Application Ref:	3/2026/0426			 Ribbles Valley Borough Council www.ribblesvalley.gov.uk
Date Inspected:	17/07/26	Site Notice:	17/07/26	
Officer:	AR			
DELEGATED ITEM FILE REPORT:				APPROVAL

Development Description:	Proposed 1.5, high 'ball top' fencing to the existing masonry wall boundary, including magnetic locks and audio intercom system.
Site Address/Location:	Ribchester St Wilfrids C of E Primary School Ribchester PR3 3XP

Proposed Plans, Scale : 1:200

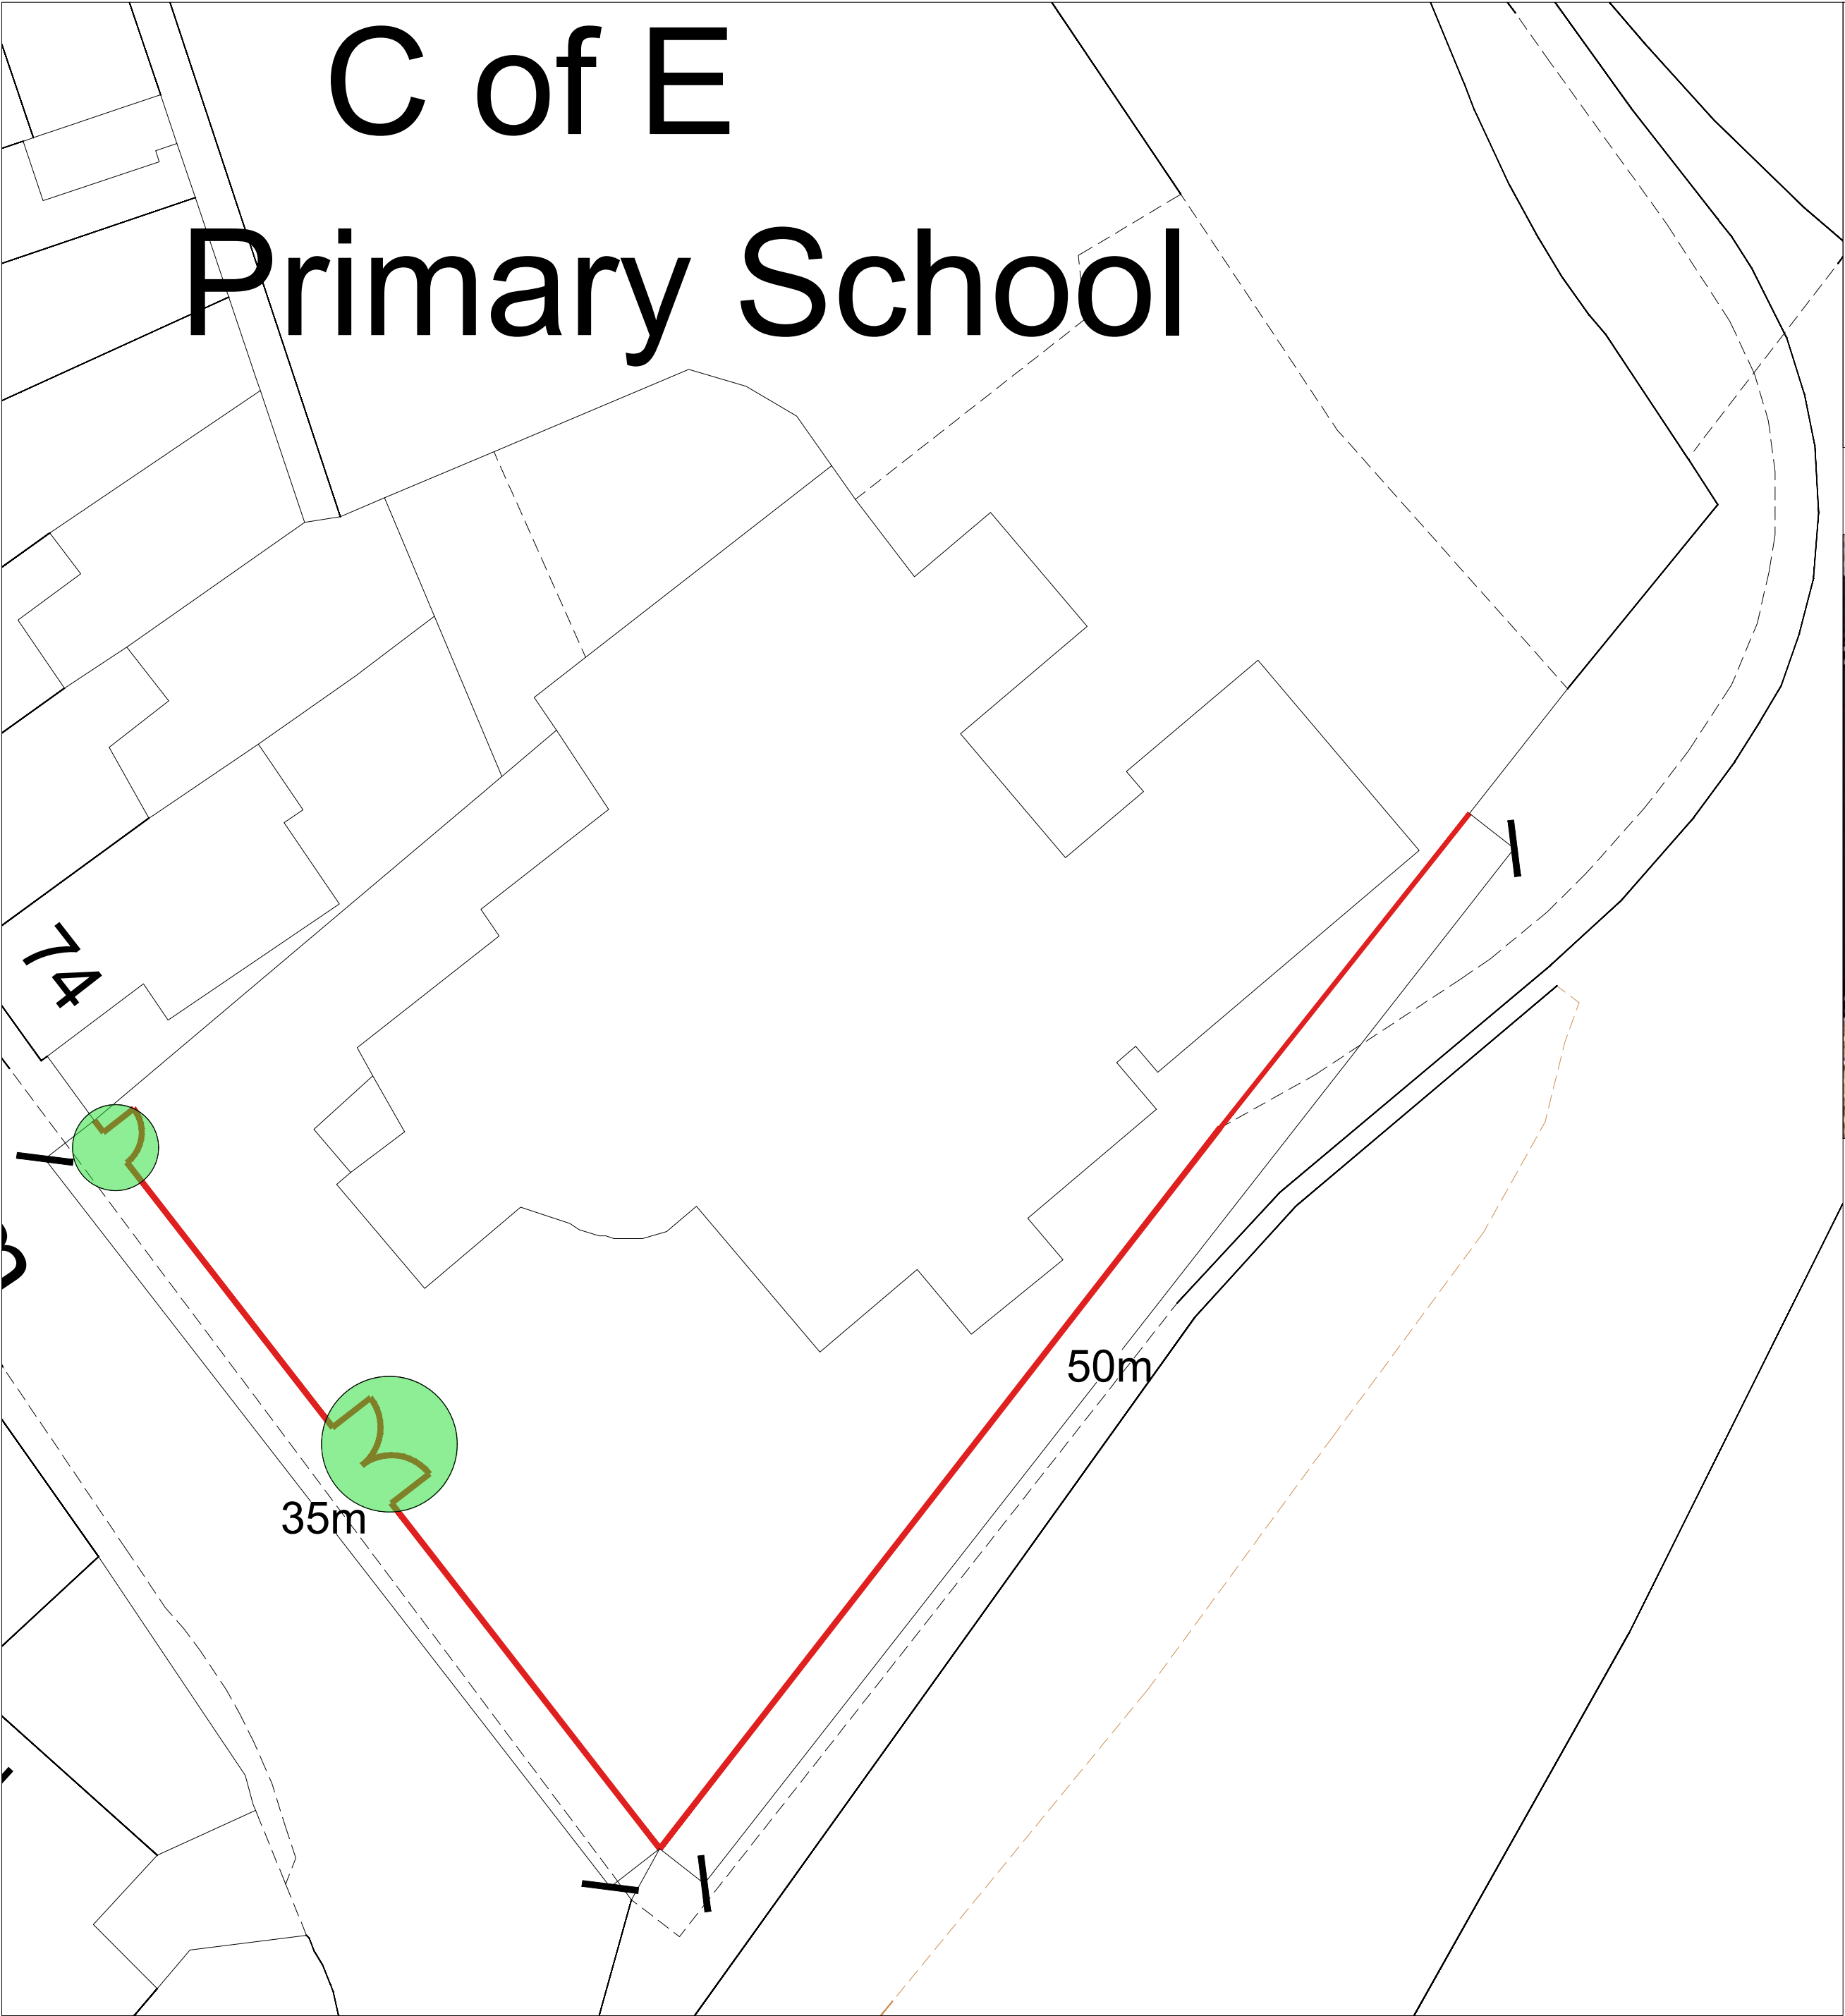
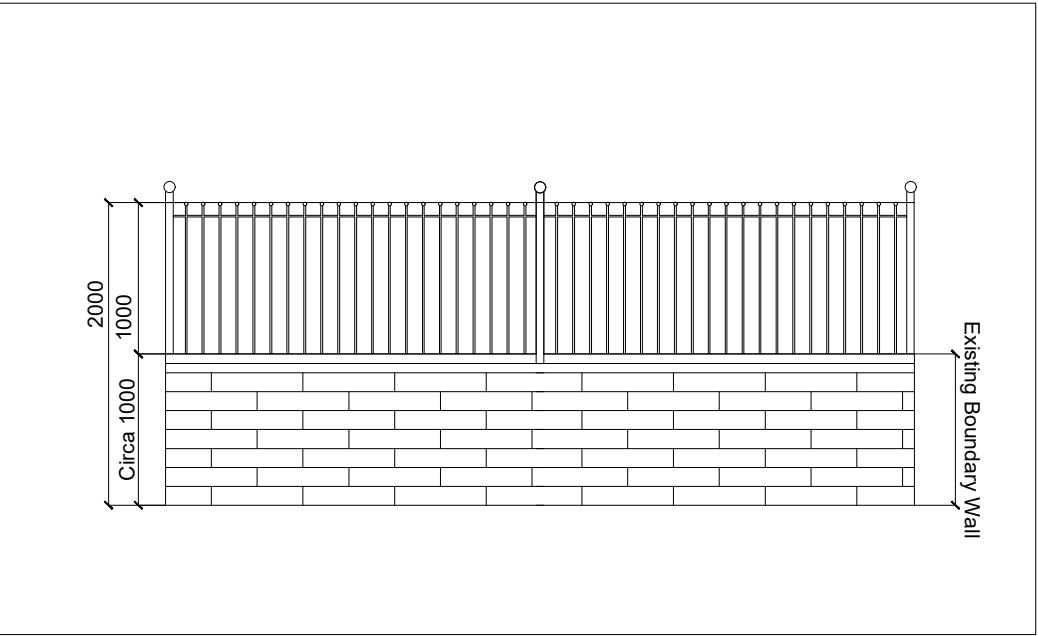
Prior to the determination of this proposal, amendments were submitted at the request of the planning officer to reduce the proposed fence height to 1 metre, with the boundary treatment not exceeding a maximum height of 2 metres.

Proposed Plans, Scale : 1:200

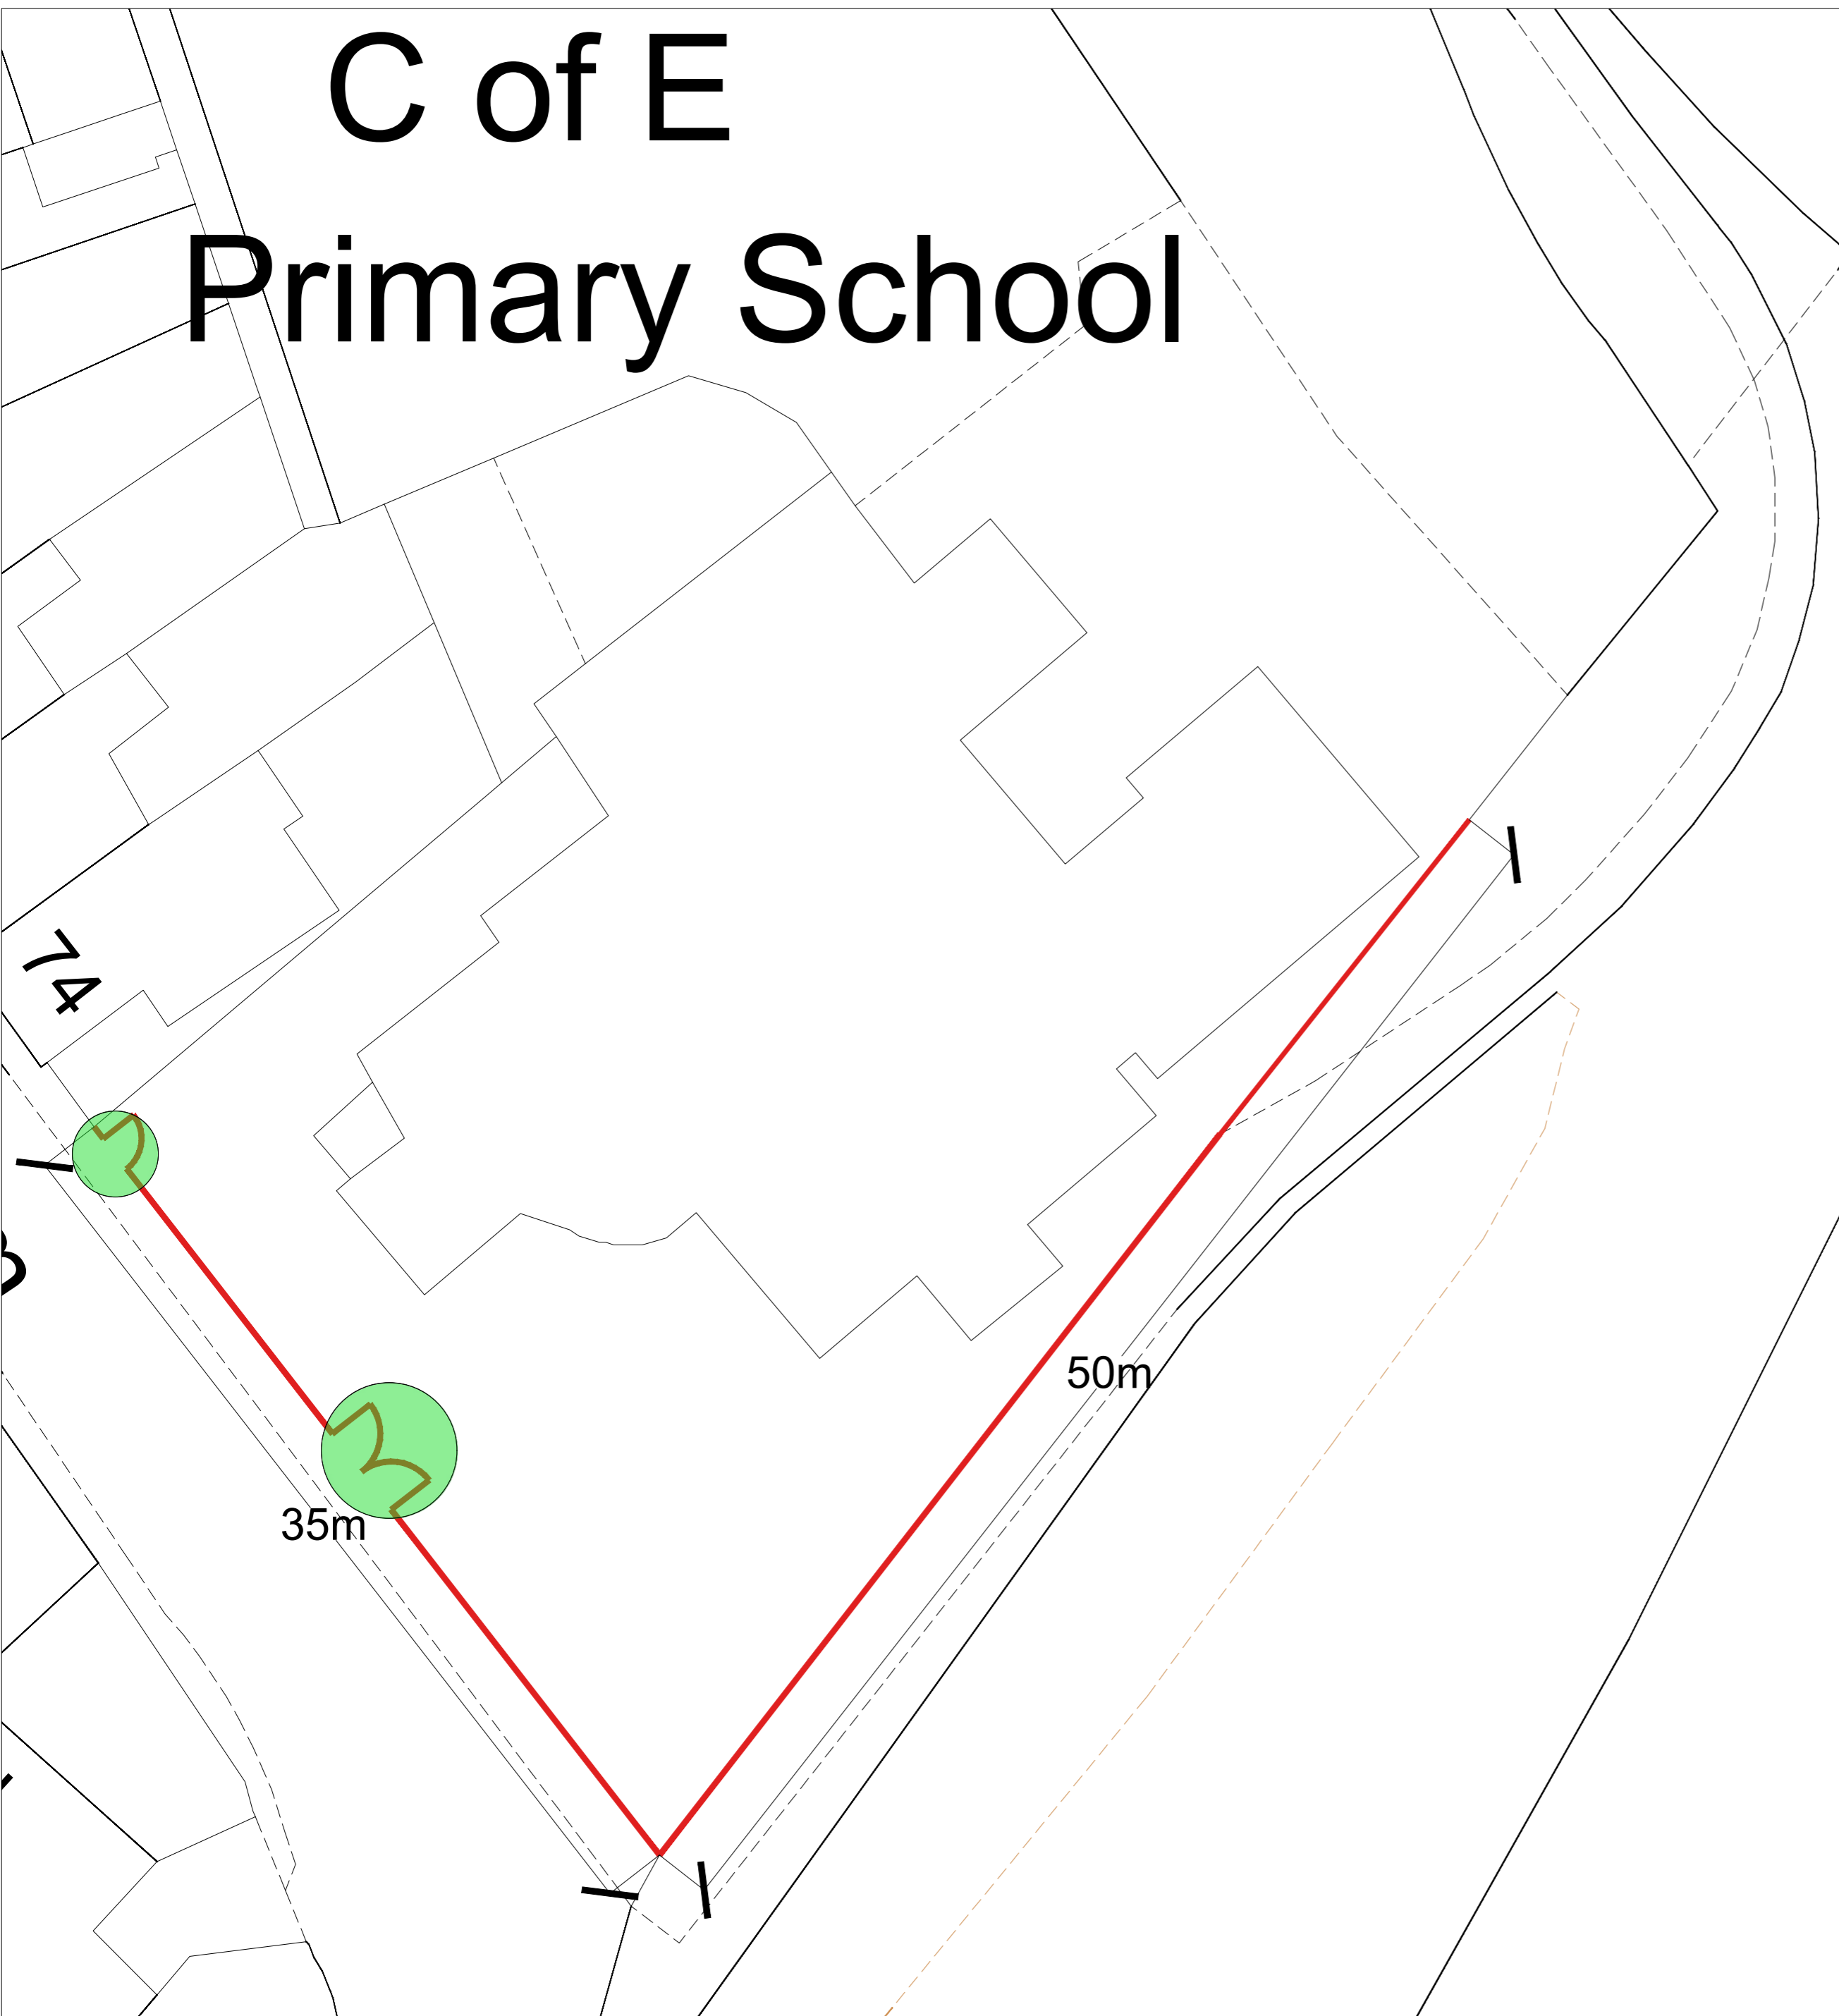
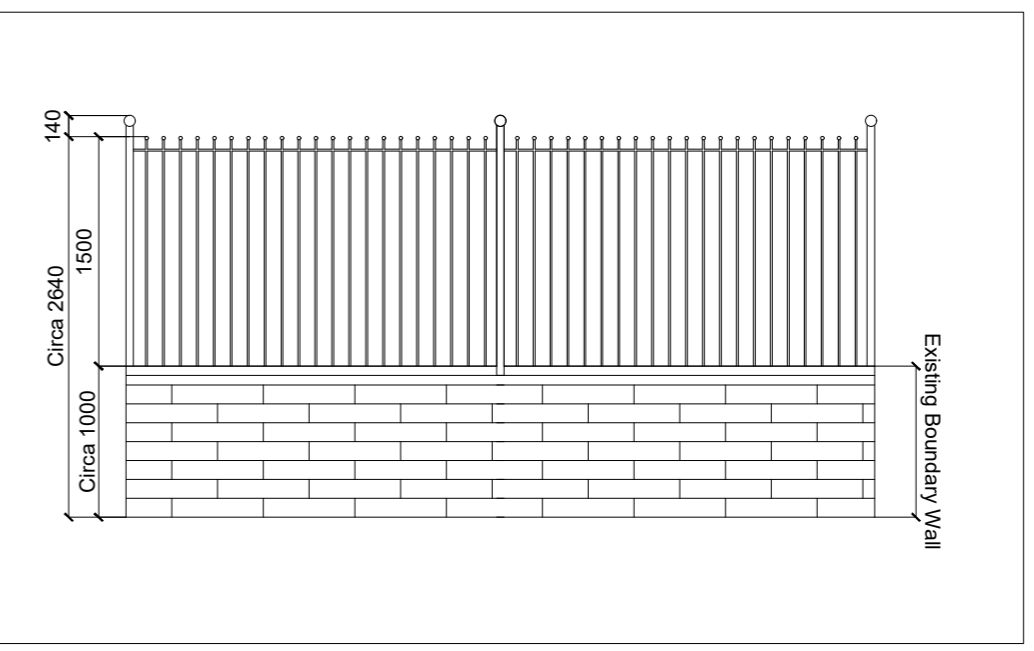
The main impact of the proposed development is the siting, design and materials used for the proposed fencing. The proposed fencing would sit on top of the existing 1m stone wall boundary treatment on the south-western and south-eastern boundaries, with a maximum height of 2.6m and would therefore be highly visible to the adjoining public realm. Therefore, the planning officer has sought amendments to reduce the overall maximum height of the proposed boundary treatment to 2m to reduce its visual impact and undue harm to the important views of the River Ribble and its landscape.
